Rachel Emmett
Architectural Liaison Office
Lancashire Constabulary
Saunders Lane
Hutton
Preston
Lancashire
PR4 5SB
01772 412 892
07432629040

29th September 2014

Outline Planning Application 3/2014/0831 for residential housing development of around 25 dwellings at Whiteacre Lane, Wiswell, Barrow

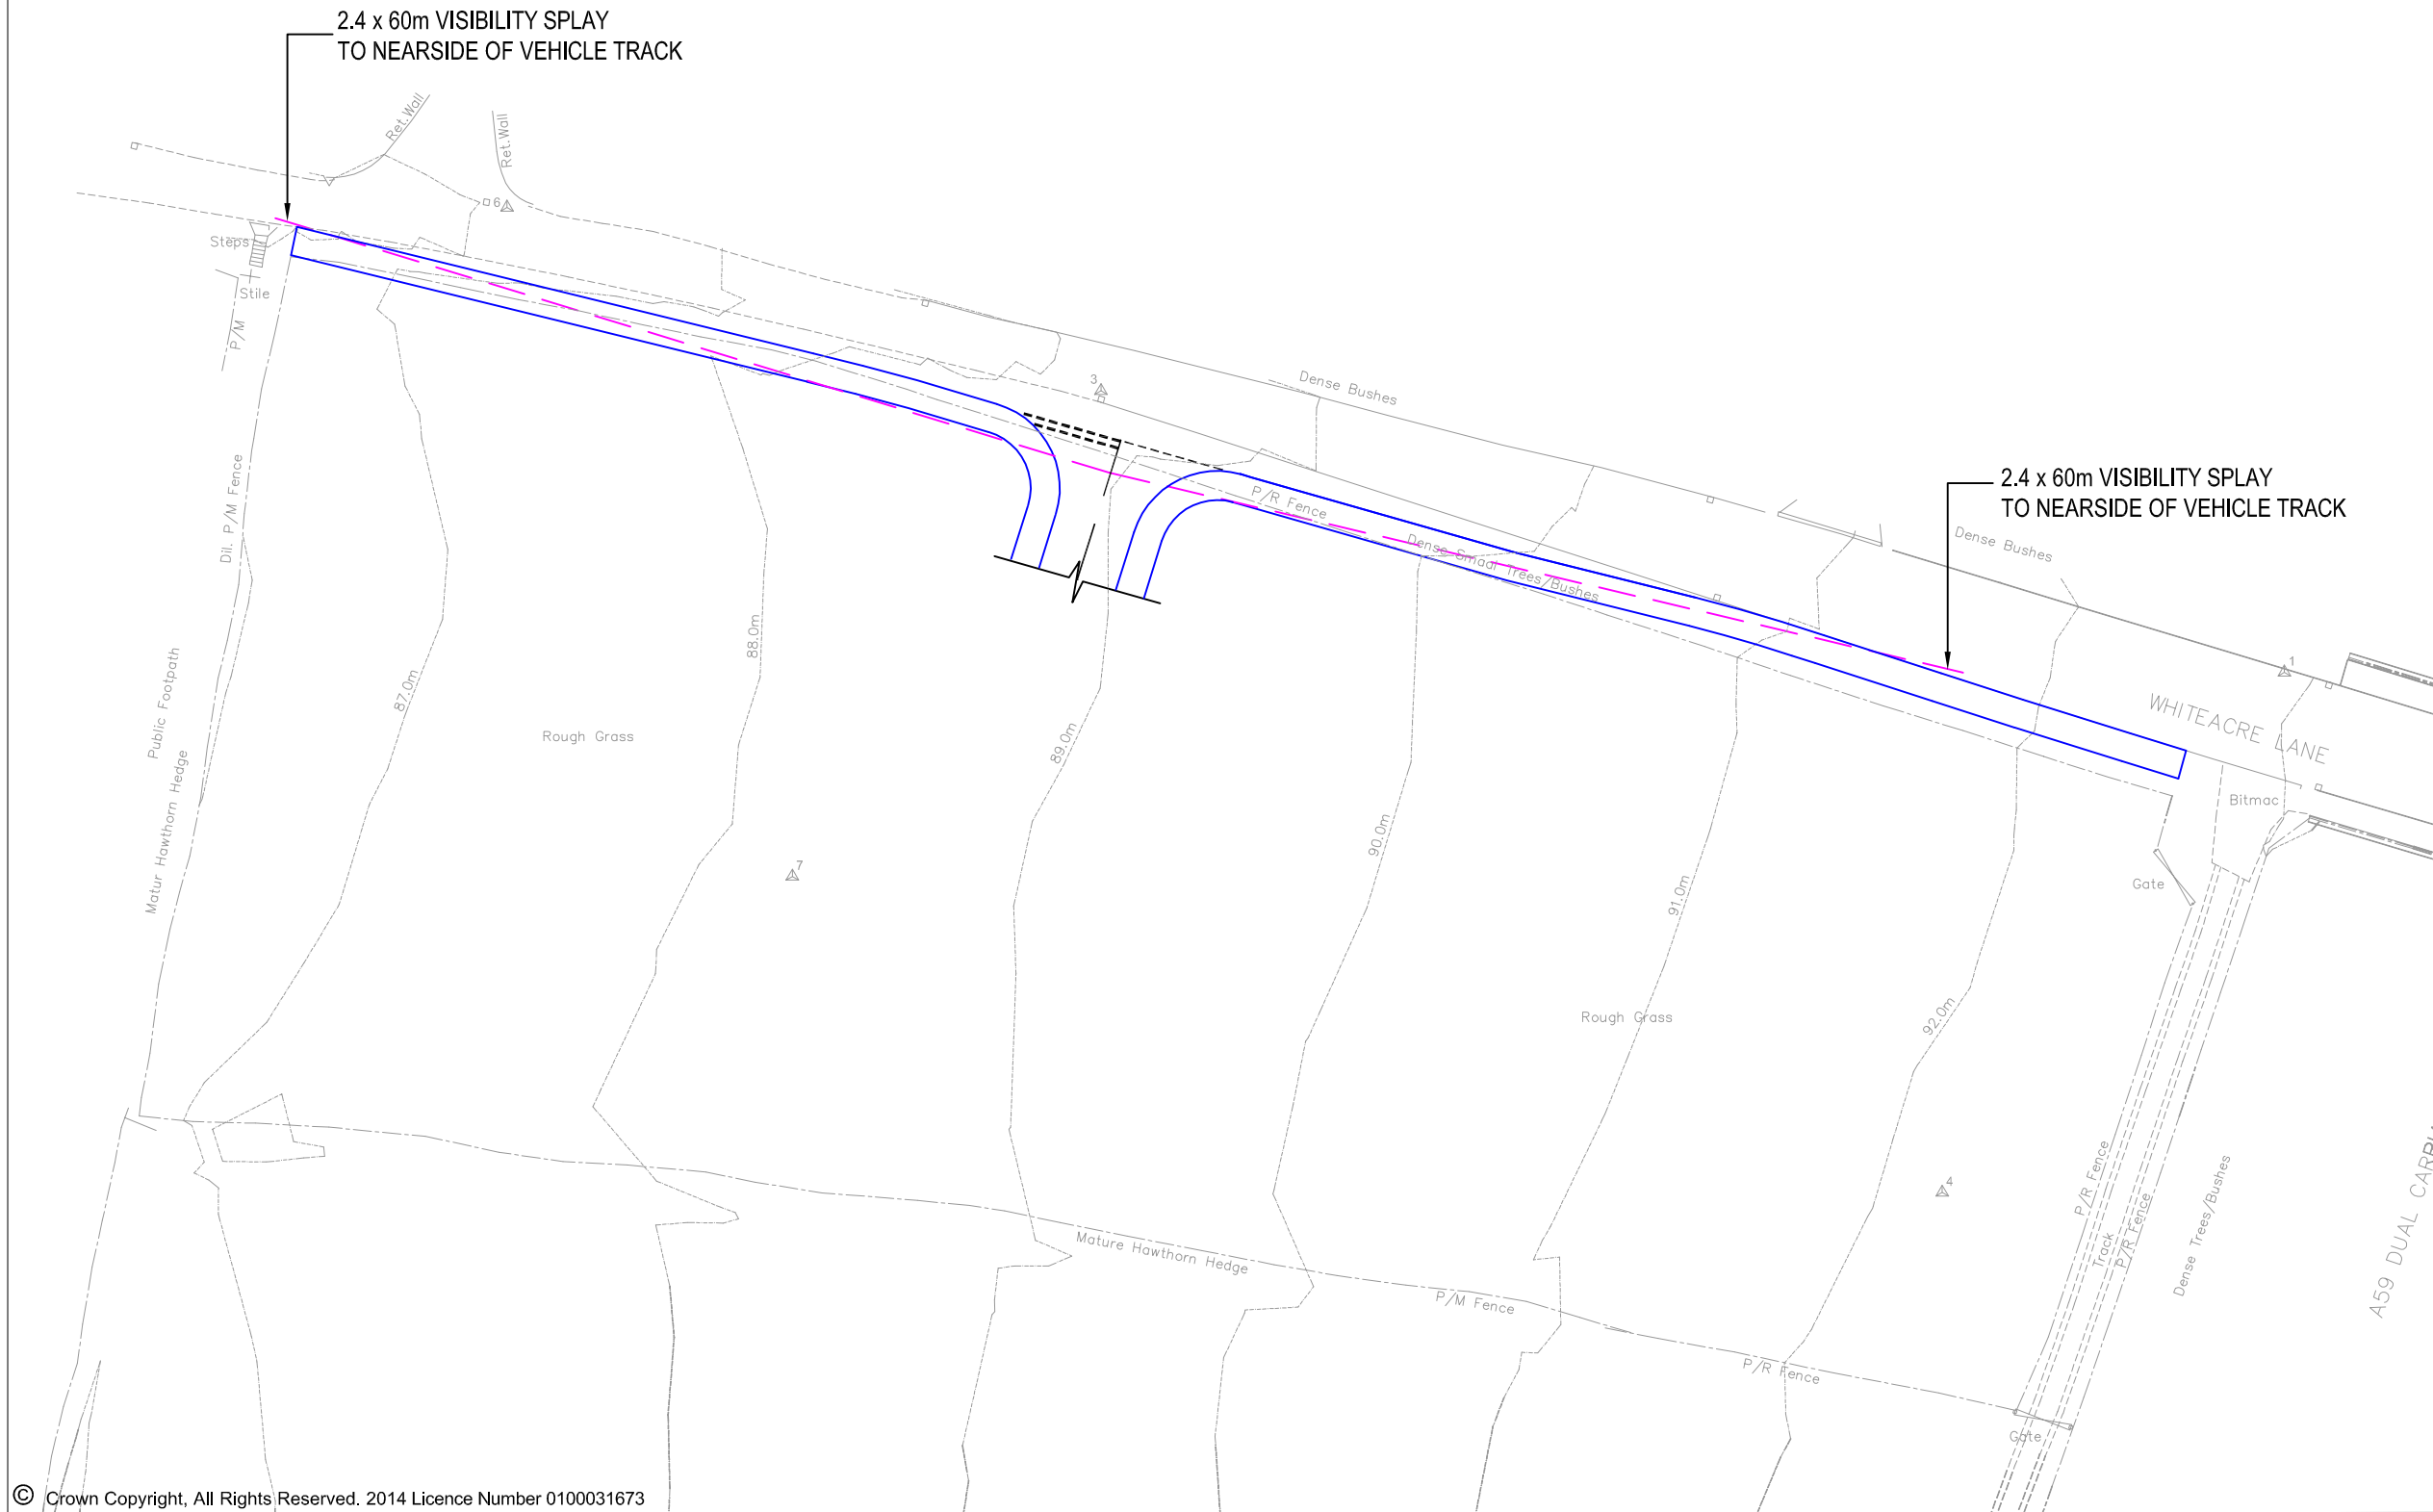
With regard to the layout, differing orientation of dwellings allows good natural surveillance which deters casual criminals looking for crime opportunities such as open windows, insecure garage doors and rear access gates.

Cul de sac arrangements also deter intruders as they are more likely to be observed by a resident. The security of the layout should not be compromised by introducing link footpaths.

Rear access alleys should be avoided as they give secluded access to the vulnerable rear of the dwellings. Where absolutely necessary, access into the alley should be restricted by a lockable gate and the entrance should be covered by the street lighting scheme.

Back to back rear gardens help to afford security to the dwellings.

Parking should be in curtilage to reduce the risk of auto-crime.
